CITY OF ALBUQUERQUE

September 17, 2021

Re: **VCA Vet Care Hospital**
8850 Holly Ave NE
Traffic Circulation Layout
Engineer's/Architect's Stamp 09-14-2021 (C20-D071)

TCL-001

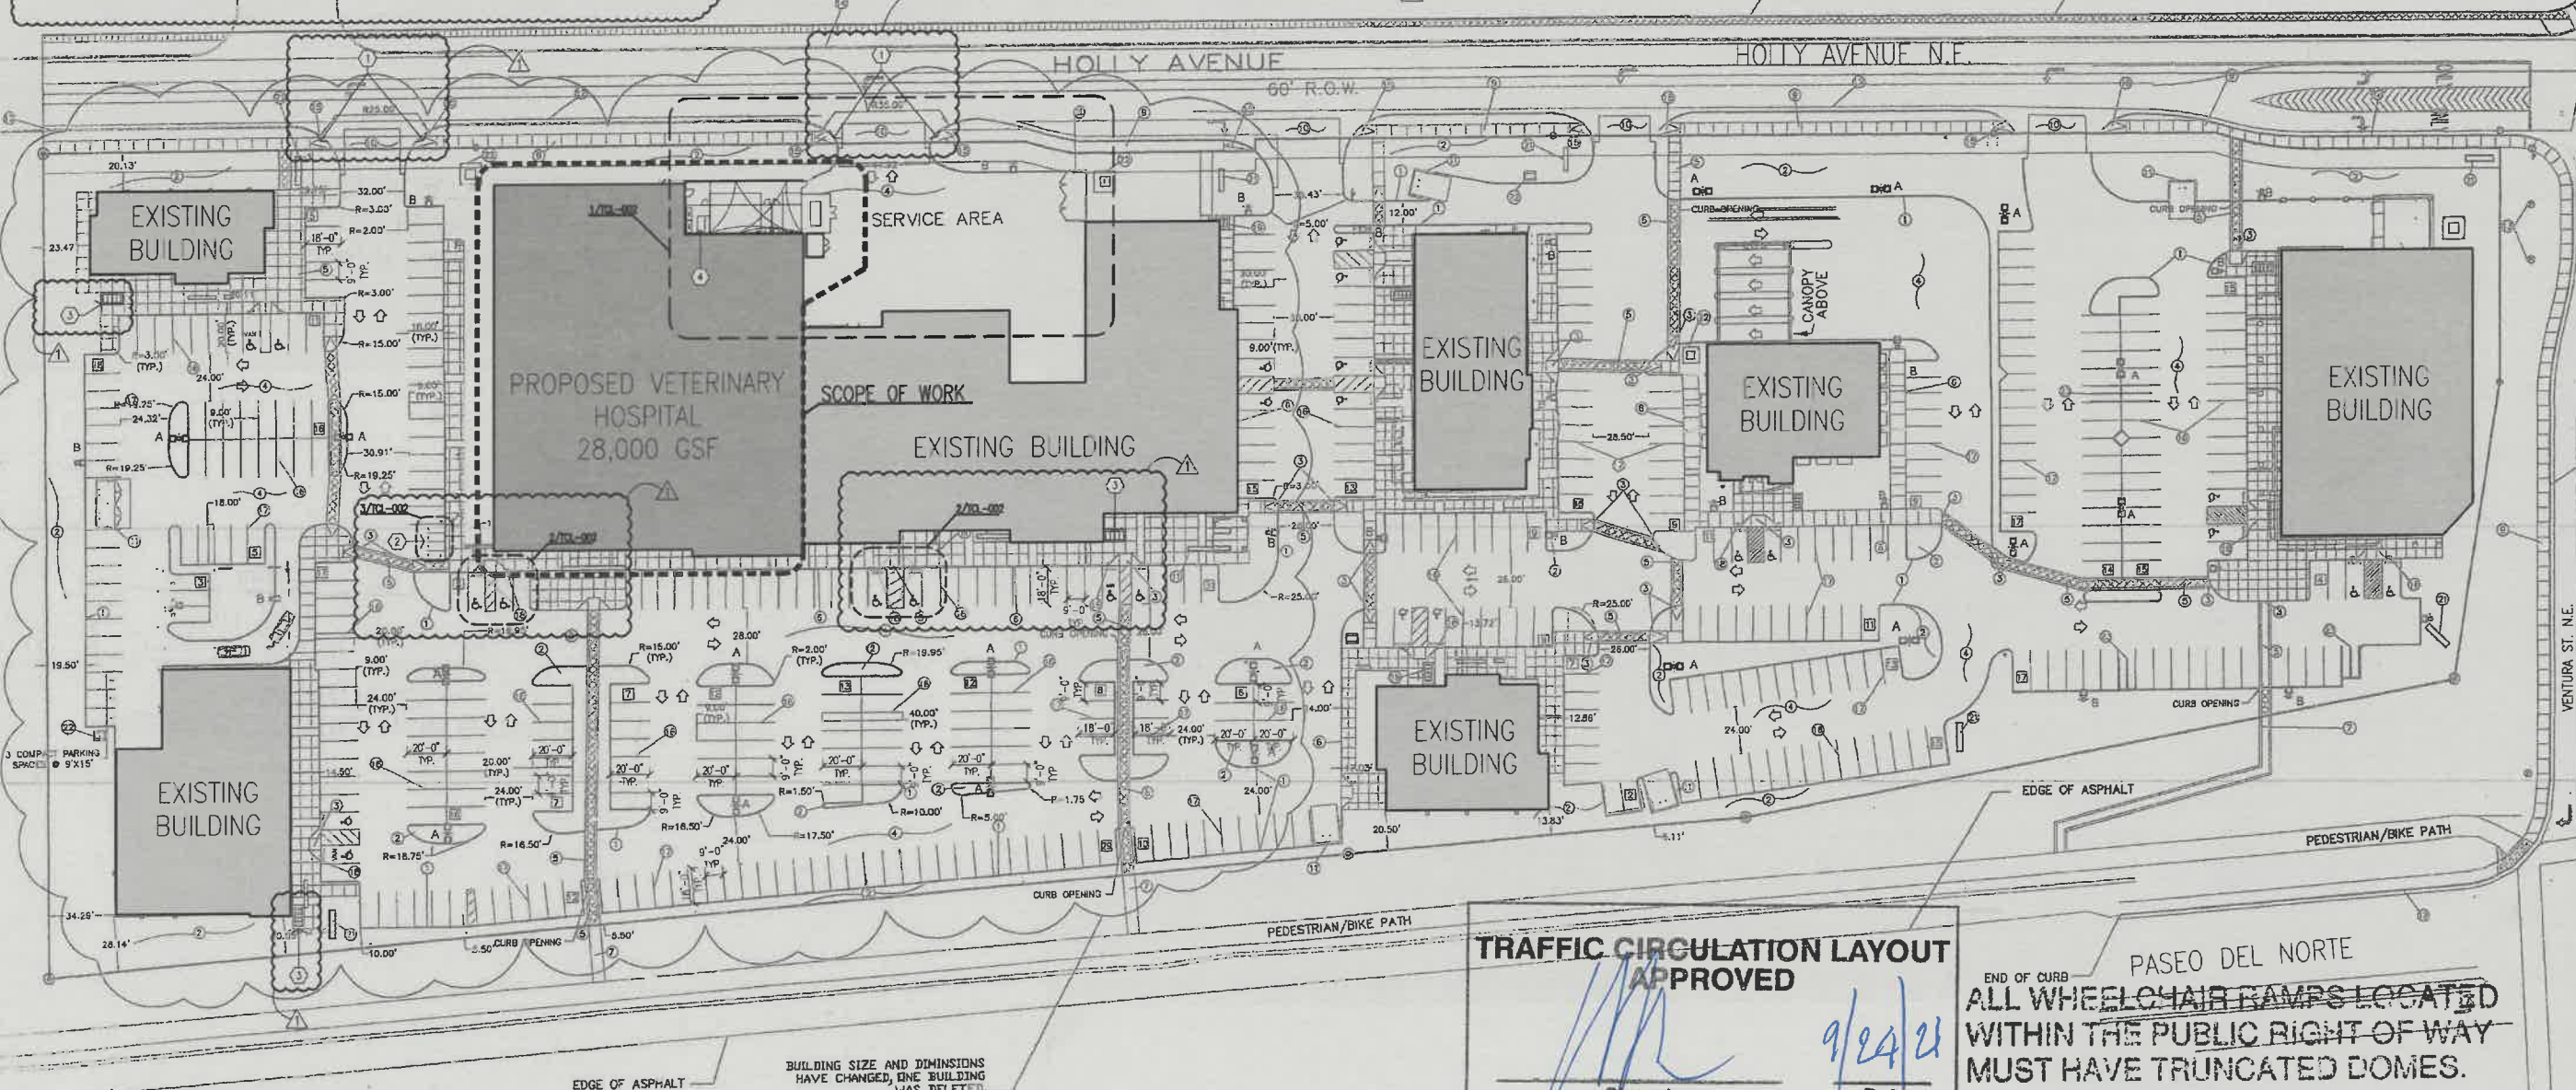
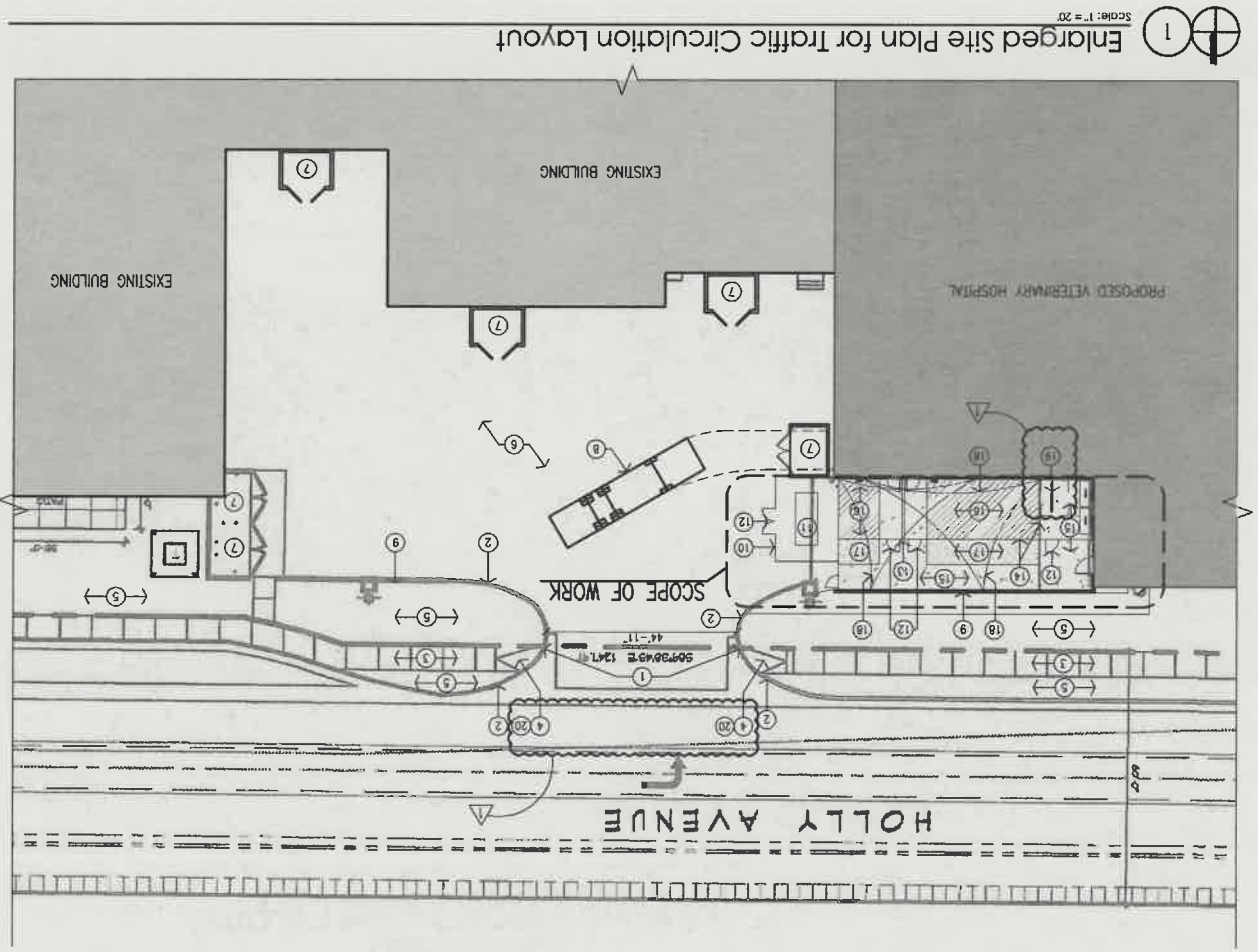
1. Please show a vicinity map showing the location of the development in relation to streets and well known landmarks.
2. Listed are the number of parking spaces required by the IDO as well as the proposed number of parking spaces including bicycle and motorcycle parking. Coordinate/discuss with Zoning **(IF APPLICABLE)**.
3. Please identify all existing buildings, doors, structures, sidewalks, curbs, drive pads, wall and anything that influences the parking and circulation on the site.
4. The existing plan shows 2 sets of ADA parking stall but on site there only exists one set of ADA (Handicap) parking stalls. **Please modified existing Site Plan to reflect existing conditions.**
5. Please list the width and length for all existing and proposed parking spaces. Some dimensions are not shown.
6. The minimum parking stall dimensions are:

7. The ADA accessible spaces must include an access aisle. **Van accessible aisles should be 8ft wide;** all others should be 5ft wide.
8. The ADA accessible parking sign must have the required language per 66-7-352.4C NMSA 1978 **"Violators Are Subject to a Fine and/or Towing."** Please call out detail and location of signs.

9. The ADA access aisles shall have the words **"NO PARKING"** in capital letters, each of which shall be at least one foot high and at least two inches wide, placed at the rear of the parking space so as to be close to where an adjacent vehicle's rear tire would be placed. (66-1-4.1.B NMSA 1978)

10. ADA curb ramps must be **updated to current standards and have truncated domes** installed:
 - 25 ft Entrance ramps (Holly AVE.)
 - Ramps at back of building 35 ft Entrance.

11. Motorcycle parking spaces shall be designated by its own conspicuously posted upright sign, either free-standing or wall mounted per the zoning code. Label pavement MC.

18. Add a note stating "All broken or cracked sidewalk must be replaced with sidewalk and curb & gutter." A build note must be provided referring to the appropriate City Standard drawing (2430 & 2415A).

SHEET
TCL-003

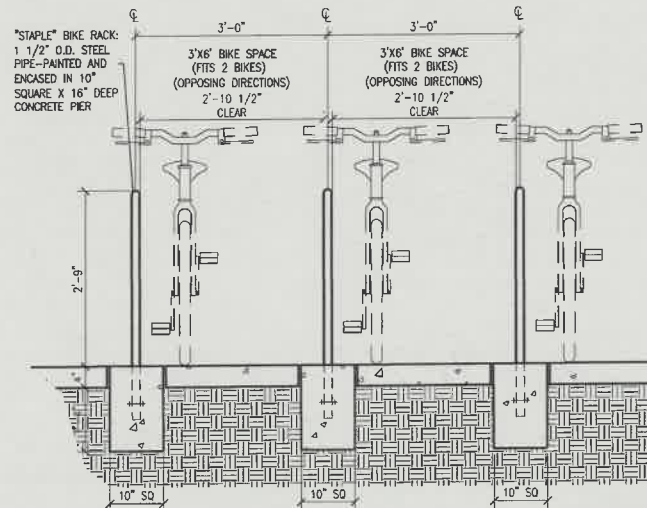
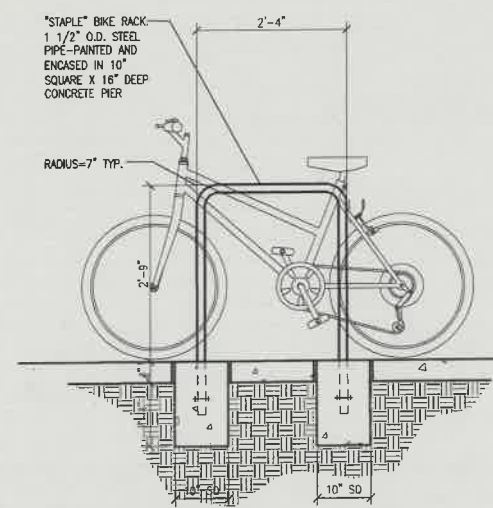
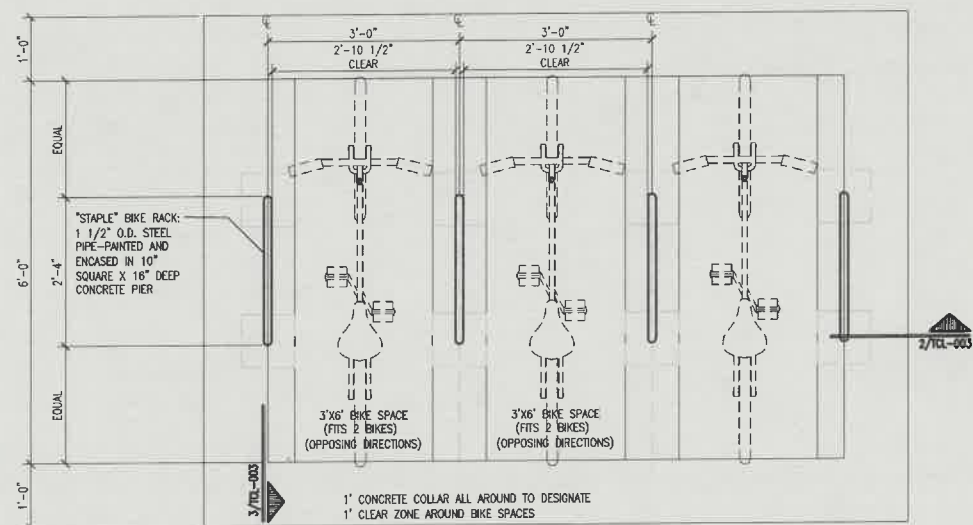
12. All bicycle racks shall be designed according to the following guidelines:
 - a. The rack shall be a minimum 30 inches tall and 18 inches wide.
 - b. The bicycle frame shall be supported horizontally at two or more places. Comb/toaster racks are not allowed.

- c. The rack shall be designed to support the bicycle in an upright position. See the IDO for additional information.
 - d. The rack allows varying bicycle frame sizes and styles to be attached.

- e. The user is not required to lift the bicycle onto the bicycle rack.
 - f. Each bicycle parking space is accessible without moving another bicycle.

13. Bicycle racks shall be sturdy and anchored to a concrete pad.
14. A 1-foot clear zone around the bicycle parking stall shall be provided.
15. Bicycle parking spaces shall be at least 6 feet long and 2 feet wide.
